Comment	Response
<p>Claire/Nat both still have some concerns regarding the timescales/construction period and the impact this will have upon marsh harrier in particular. Whilst the phasing plans are helpful, these still fail to demonstrate how long each phase is likely to take and therefore it is difficult to understand the time period between Phase 1 and Phase 3a in particular. Are you able to provide an indicative timescale for each phase or alternatively a supplementary Gantt chart which shows the length of time the construction process will take?</p>	<p>I've set out some more information below in relation to each of the phases on the phasing plan:</p> <ol style="list-style-type: none"> <li>1. Phase 1: this shows the area of the Site that requires further archaeological trenching (details of this can be seen in Appendix 7.6 of the ES Addendum). If the Site is developed as one this will be done as a pre-commencement phase. However, if the delivery of the site is phased it would be done as pre-commencement of the southern plots only (i.e. the northern area could come forward first independently). It's anticipated that the archaeological fieldworks will take c.3 months to complete.

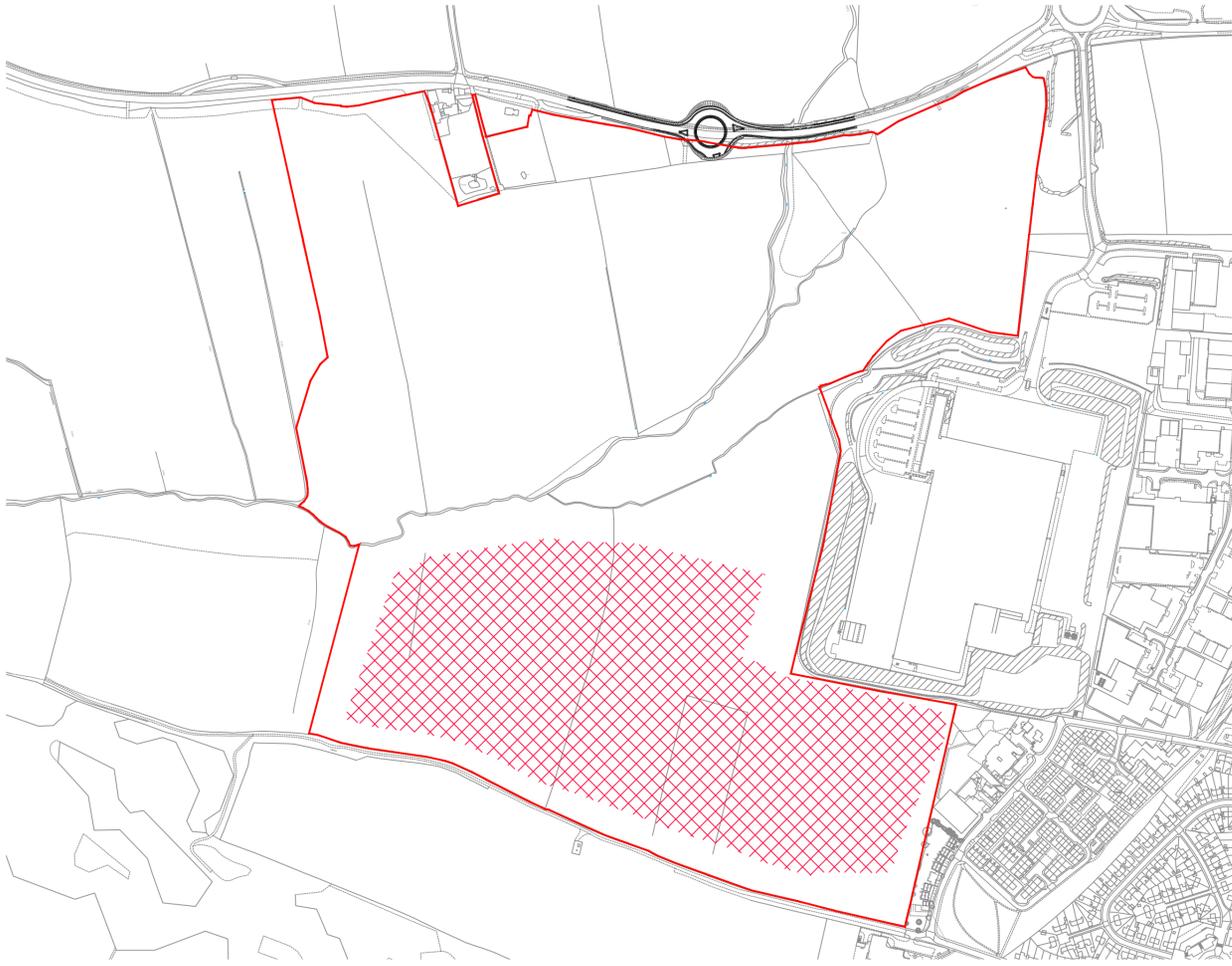
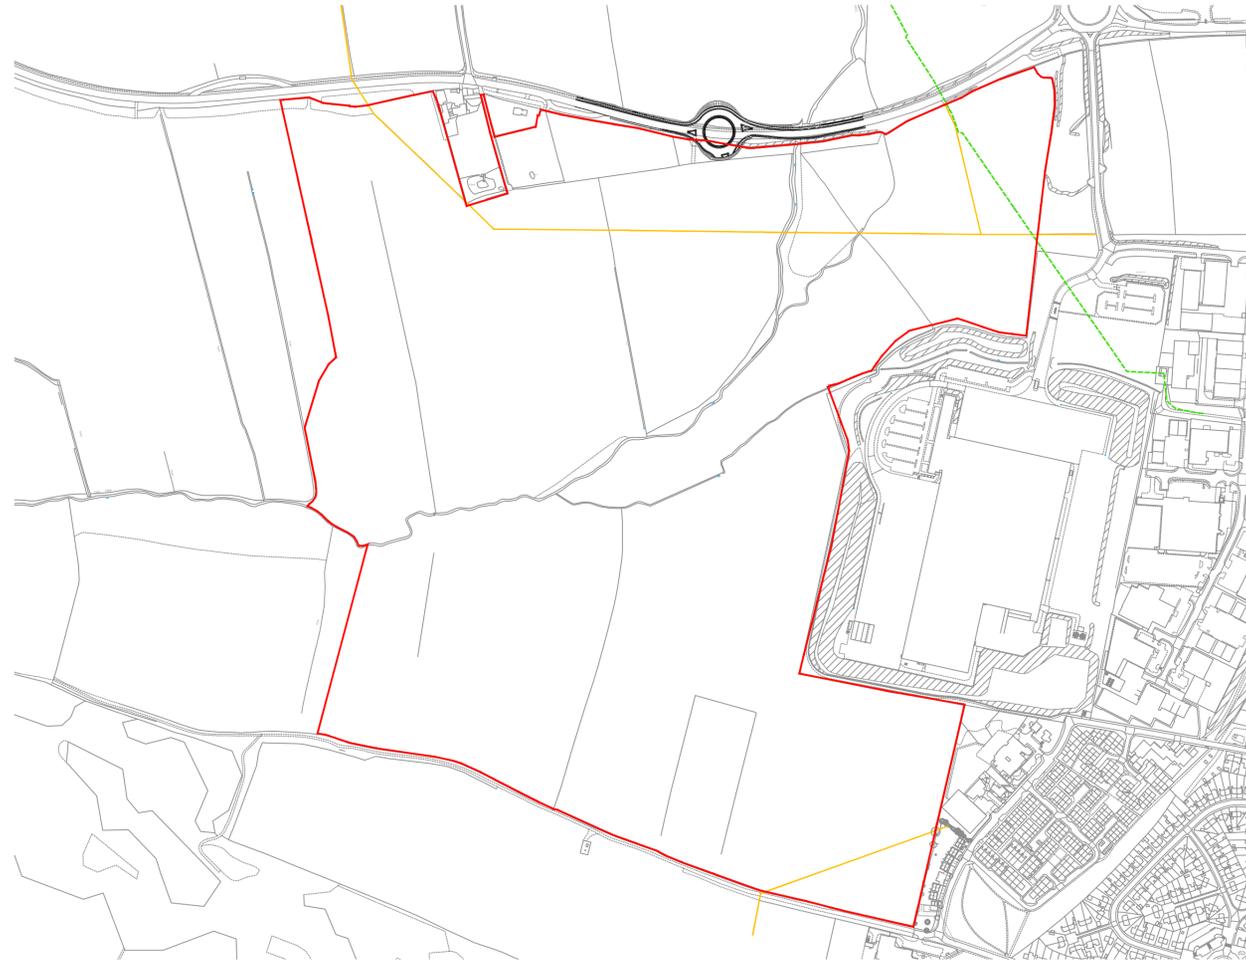
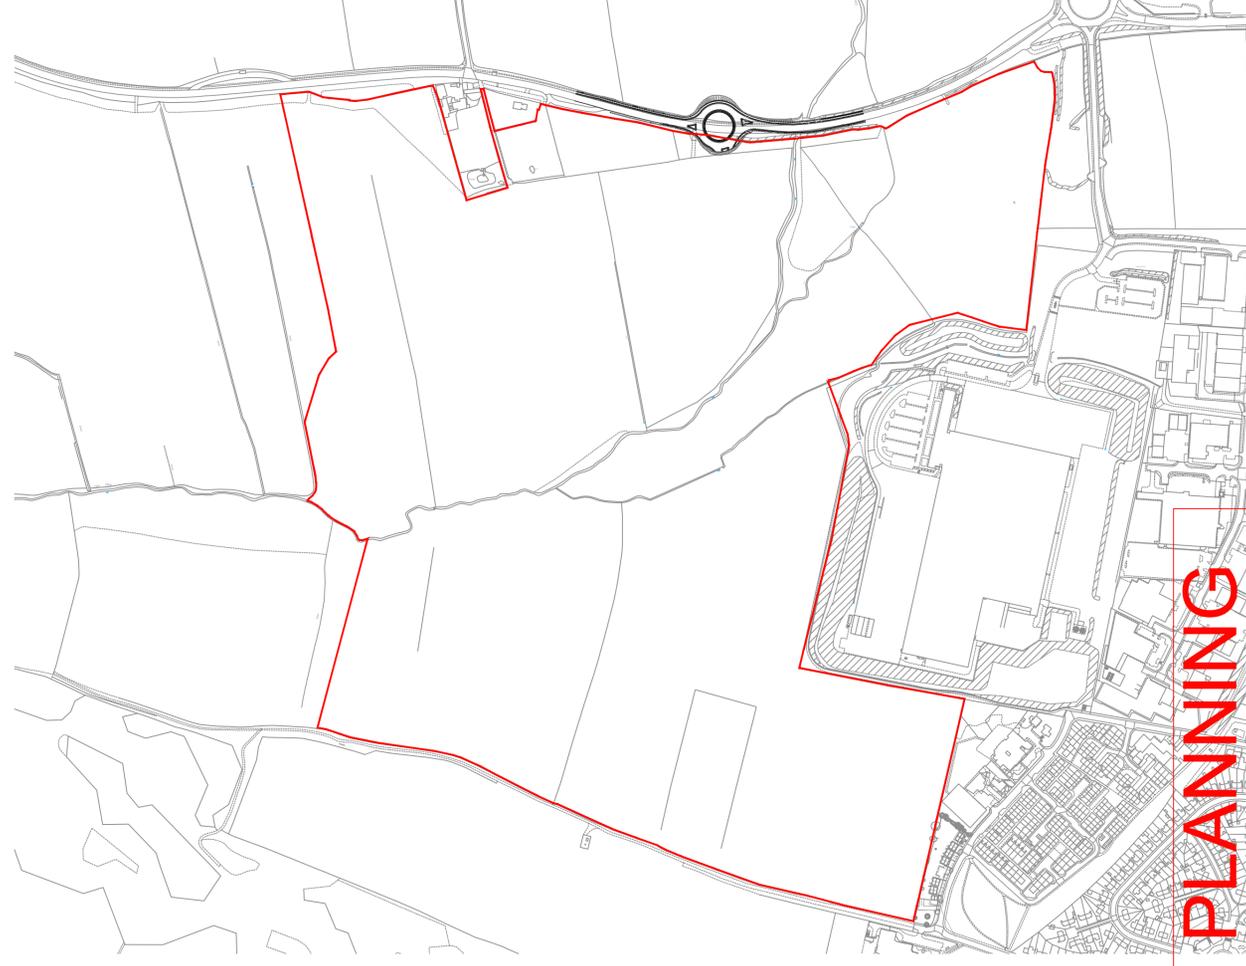
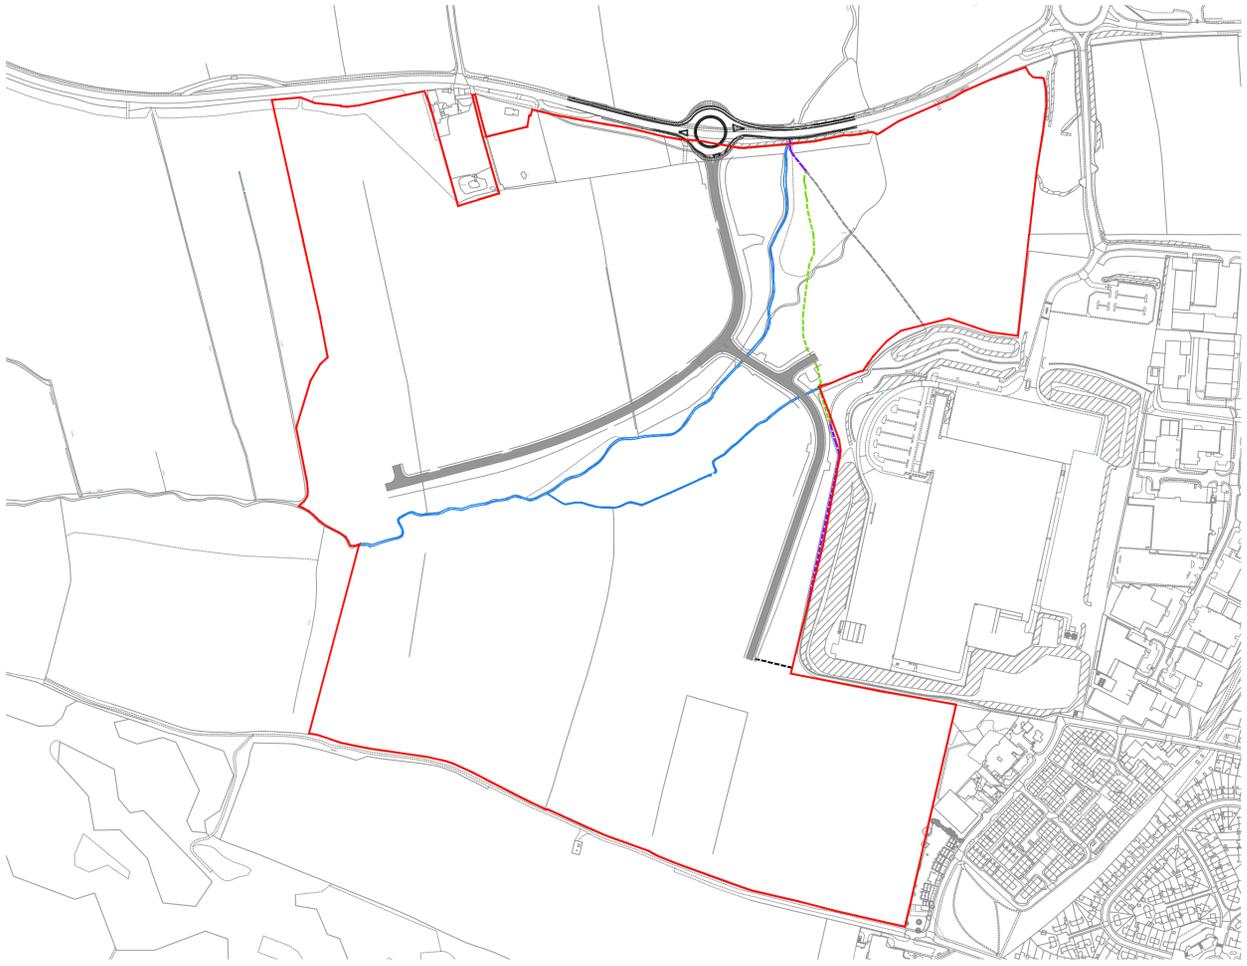
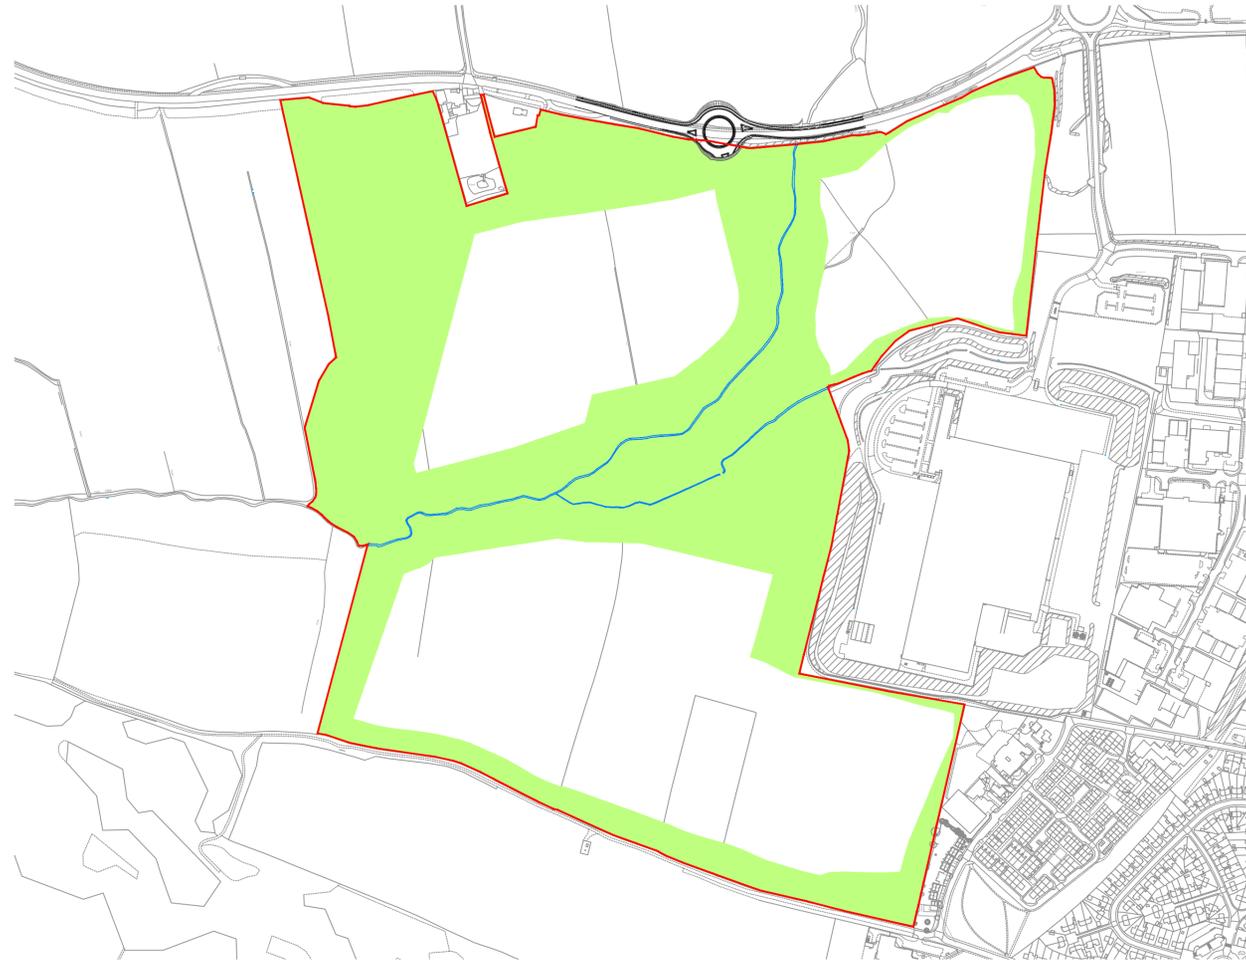
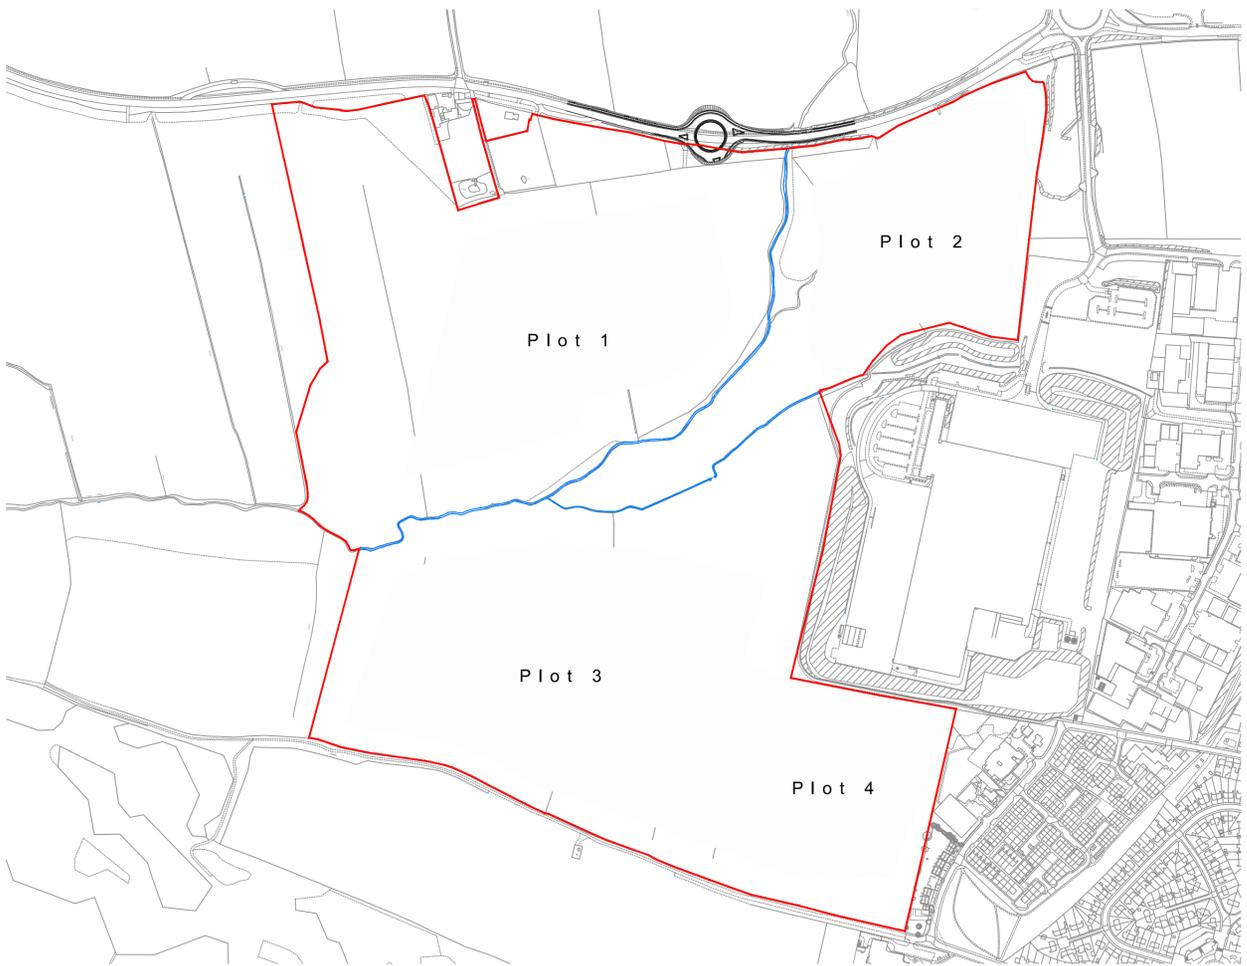
<p>Claire also questioned why the development shown in Phase 3a cannot be implemented within Phase 1? The archaeological works appear to be directed at the southern part of the site so there was a question whether these could overlap?</p>
